Please upload the attached as an amended plan for A/146/19/PL.

Please find attached an amended drawing containing the changes that you have requested – (1) removing the rear projection so that the entire garden depth is 8.5m, (2) removing the rear dormer window to Bedroom 1 replaced with 2no. roof-lights at 1.5m height in order to ensure no possibility of overlooking, and (3) and very modestly enlarging the front elevation in line with your comment.

P3	25.10.19	Revised notation.	JT	AK
P2	25.10.19	Revised red line and road name correction.	JT	AK
P1	17.10.19	Planning Issue.	JT	AK
Rev	Date	Revision Details	Dr	Ch

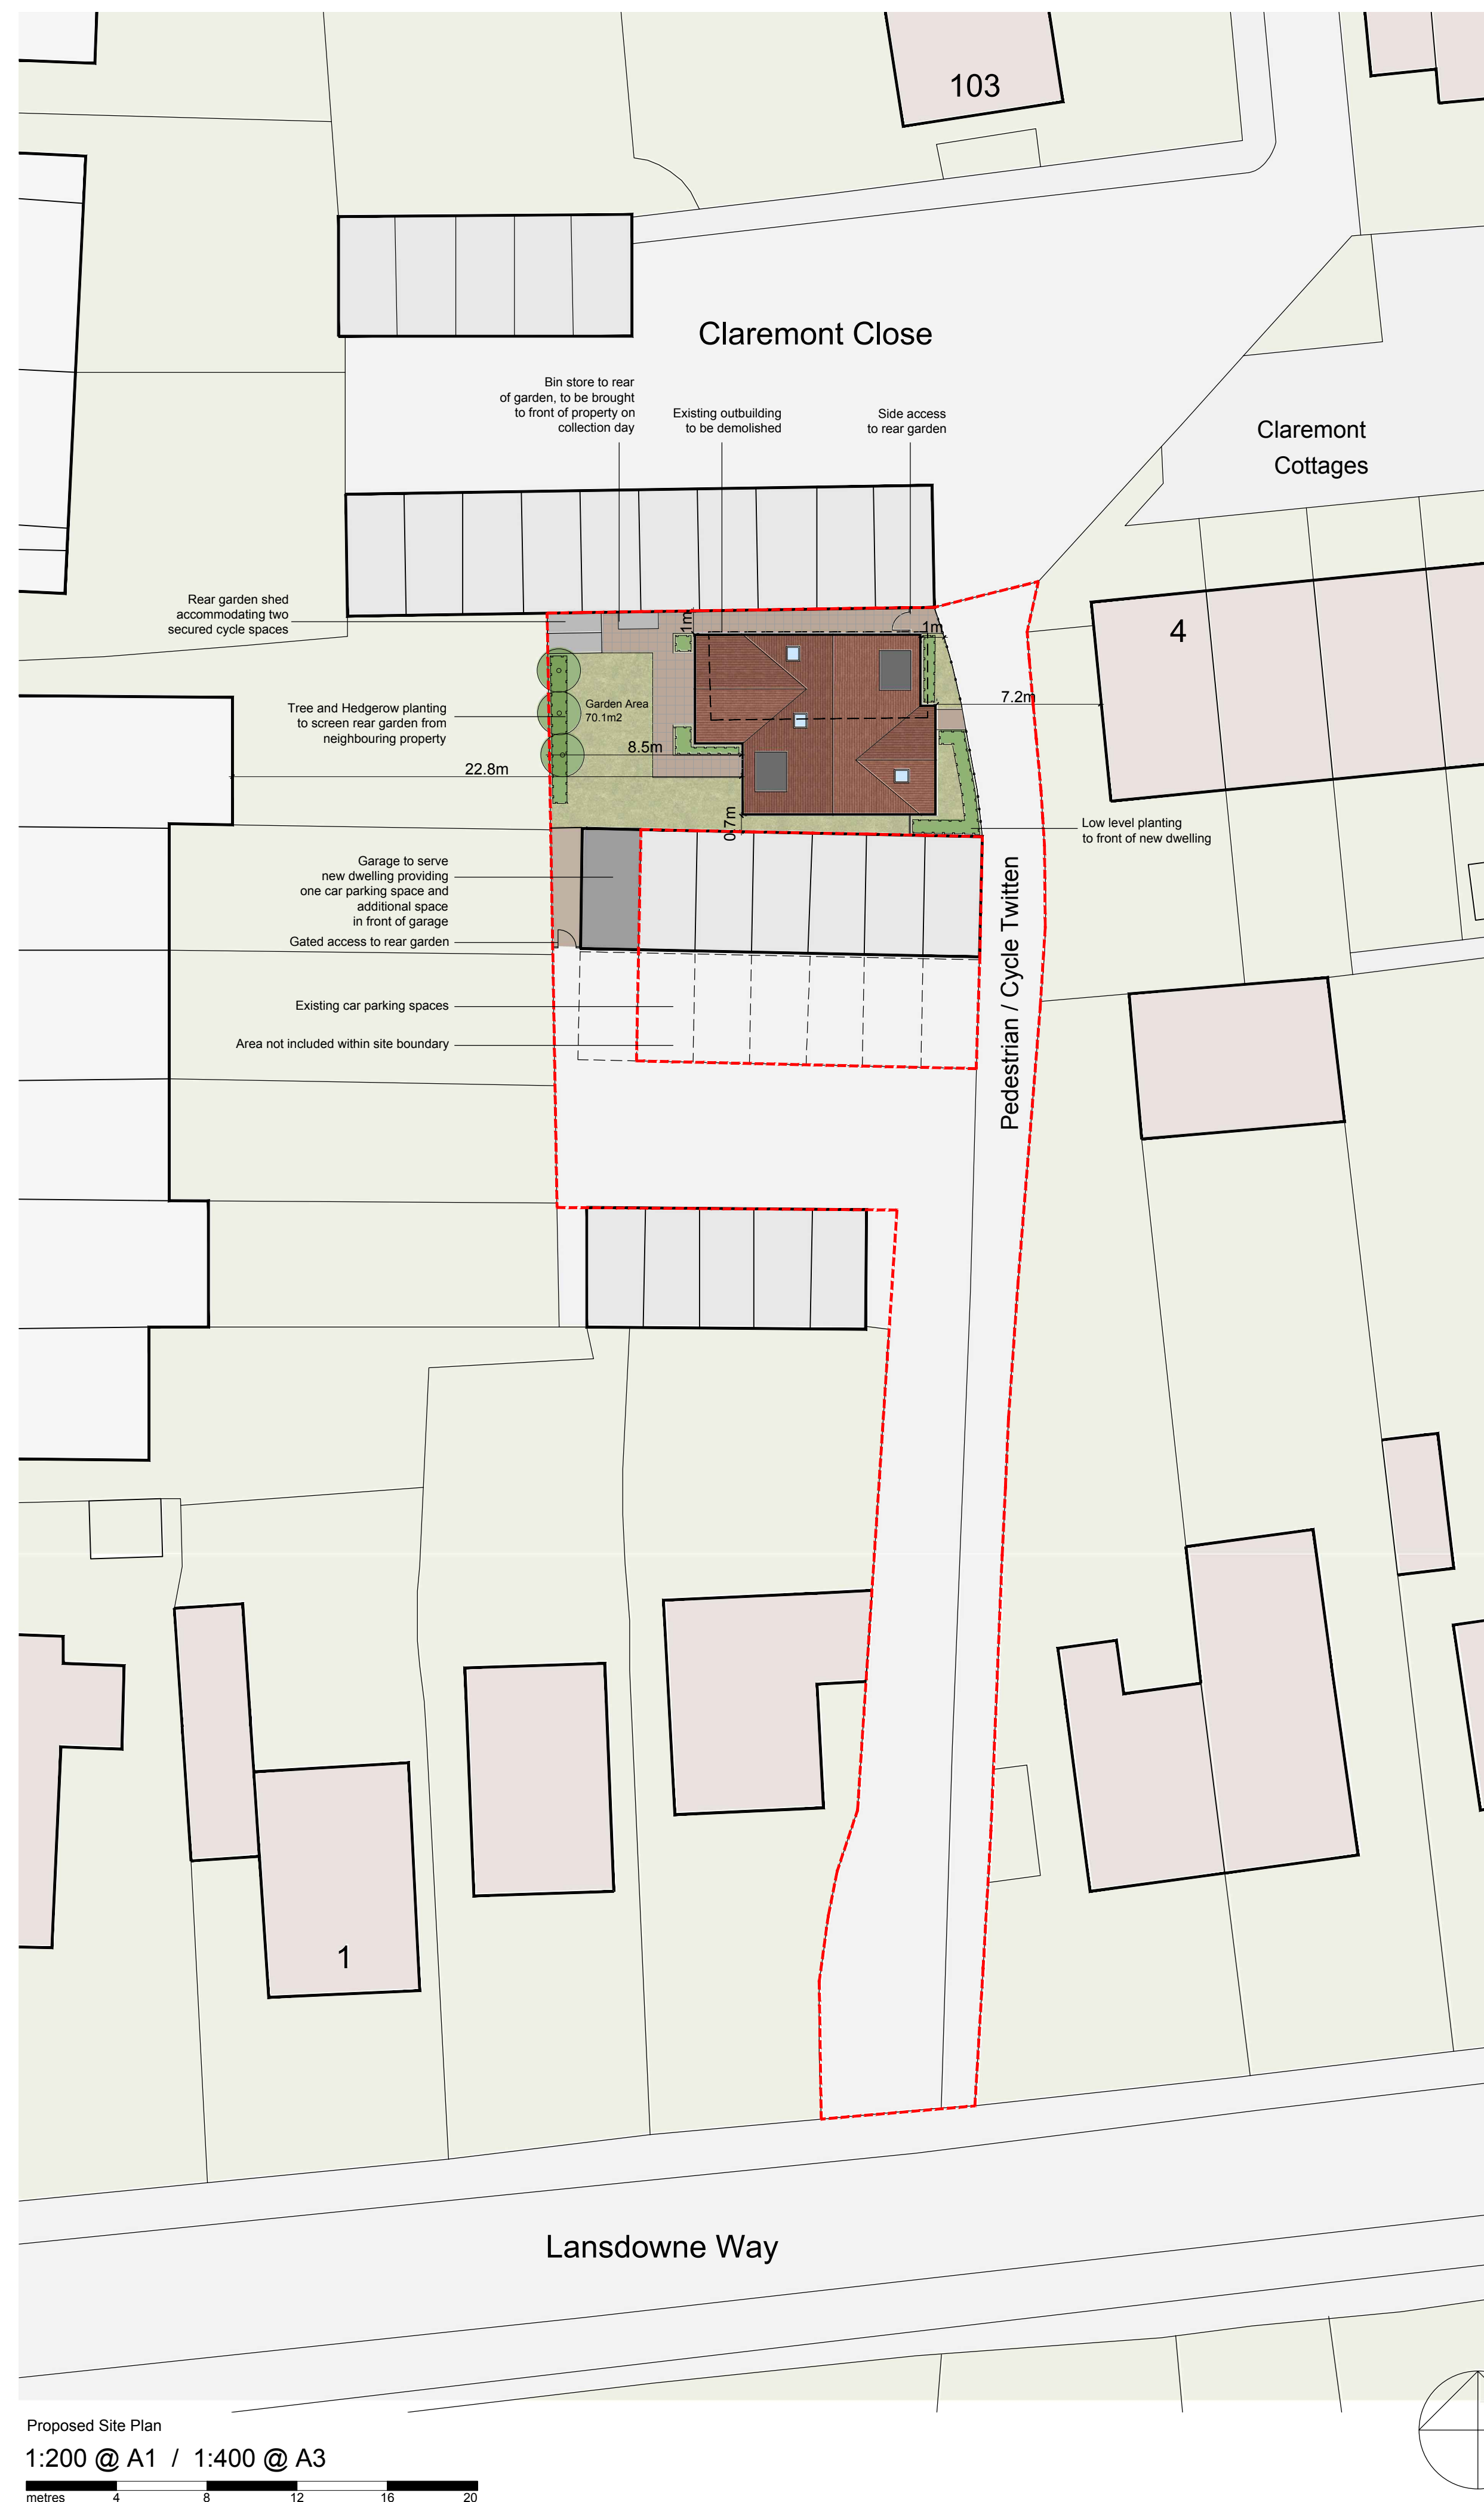
I had a chat here internally and we feel the proposal could be ok, on balance once a few changes are made. I mentioned your willingness to make whatever changes we felt necessary to get it over the line. Could you send in an amended plan removing the rear dormer (replacing it with a rooflight) and squaring off the rear elevation so that the rear garden depth would now be 8.5? If you wish you could slightly enlarge the dwelling at the front elevation to get back some internal space.

A rear garden of 8.5m in depth at maximum and 6.3m for the majority is less than what's recommended. As I'm sure you know 10 or 11m is looked at as a minimum depth. Although the principle of development is ok other issues such as above and the hemmed in nature of the proposal in relation to the rows of garages on either side are likely to be other issues for this proposal. I will have a closer look at 'Red Admiral Bungalows' and if possible visit this site when on site next week.

Your suggestion and willingness to make further amendments to the proposal in terms of the rear gable end and rear facing dormer window are also noted. However before I ask you to make any amendments I would like to carry out that site visit to see if this is what's needed to bring the proposal to a positive conclusion.
